Ribble Valley Borough Council
By email

Your ref 3/2023/0997
Our ref DC/24/524
Date 13-MAR-24

Location: The Royal British Legion Towneley Road Longridge PR3 3EA
Proposal: Proposed residential development of 12 apartments (with restricted occupancy for residents aged 55 and above)

Ground Floor Plan

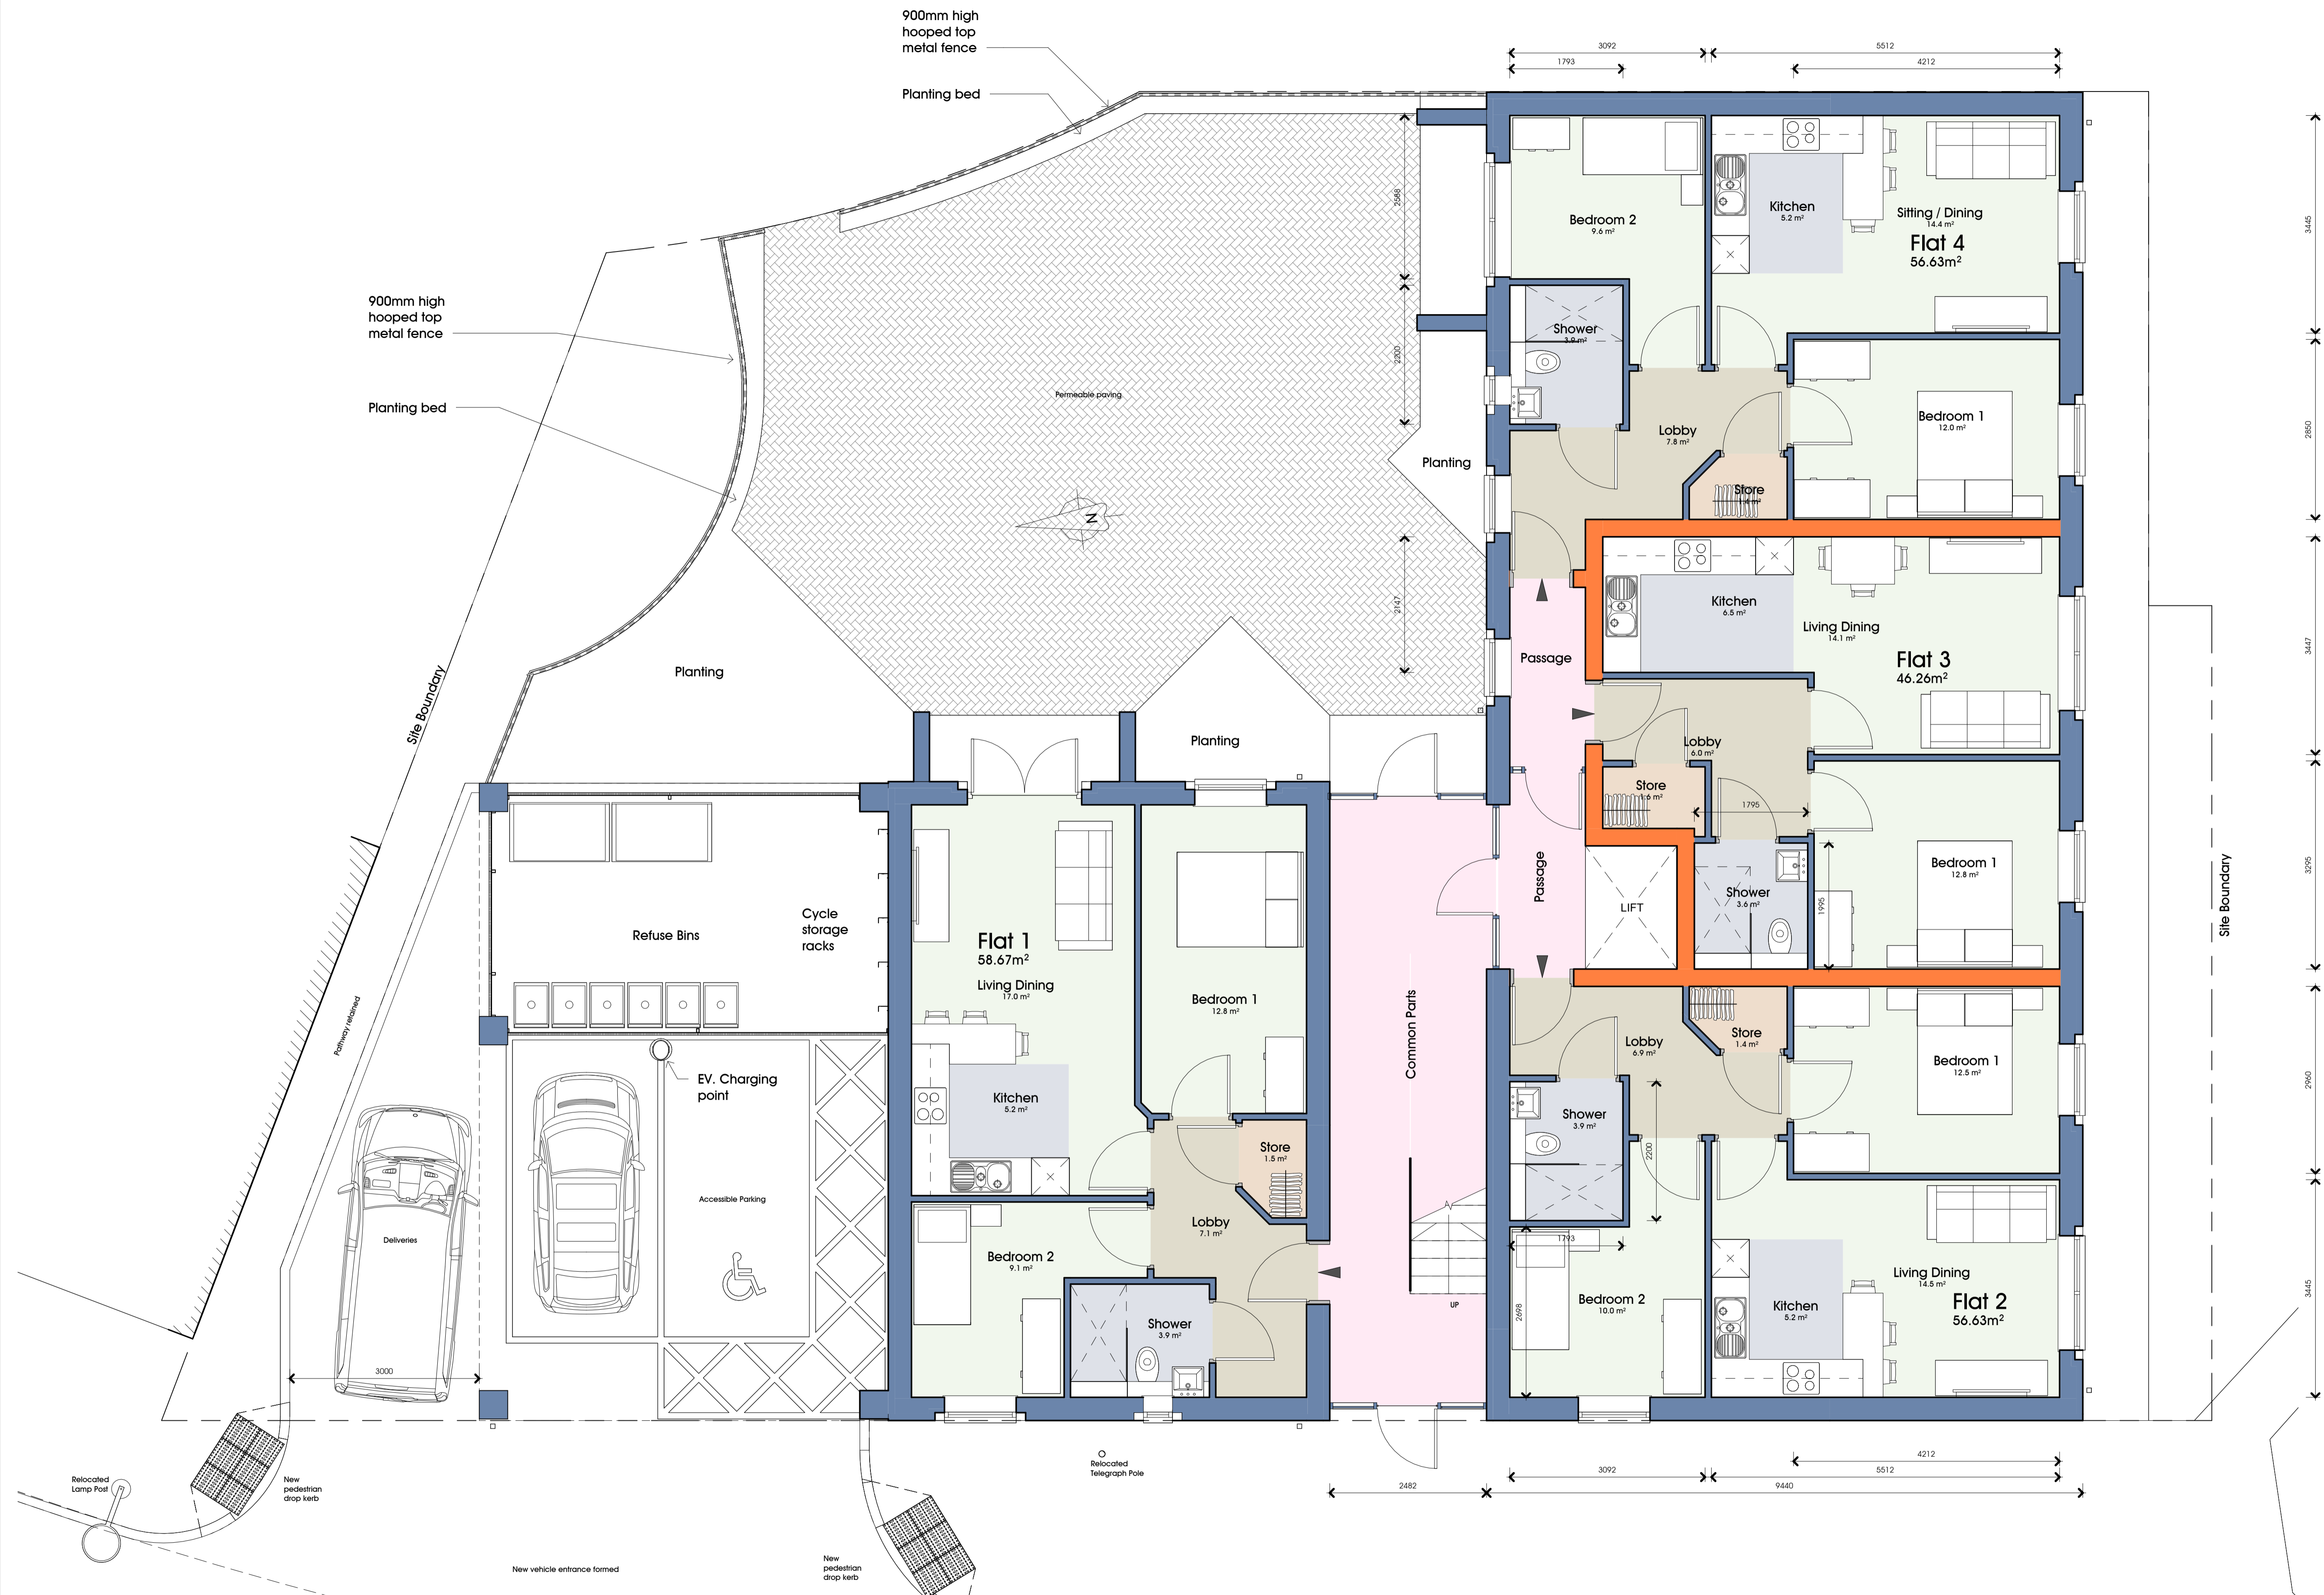
A water main is located in the vicinity of the site. It must not be built over, or our access to the pipeline compromised in any way. We require an access strip as detailed in our 'Standard Conditions for Works Adjacent to Pipelines', which can be found on our website: <https://www.unitedutilities.com/builders-developers/your-development/planning/building-over-or-working-near-our-assets/working-near-our-pipes/>. The applicant must comply with this document to ensure pipelines are adequately protected both during and after the construction period.

Based on the information currently available, it is unclear whether sufficient distance is provided between proposed development features and our water asset(s). We recommend the applicant contacts our Water Developer Services team to ensure existing water assets, along with our required access widths, can be accommodated in the proposed layout. If the applicant fails to investigate and resolve any concerns prior to a positive determination, there is a risk that as the scheme progresses, the applicant, or any subsequent developer, may discover that their plans are not implementable in their existing form or that diversion of assets is required. If the Local Authority requires any additional comment on the acceptability of the proposed layout from United Utilities, we will require a detailed site layout plan, which overlays the PROVEN location of the water asset(s) in relation to any proposed development (including walls, fencing, parking etc.).
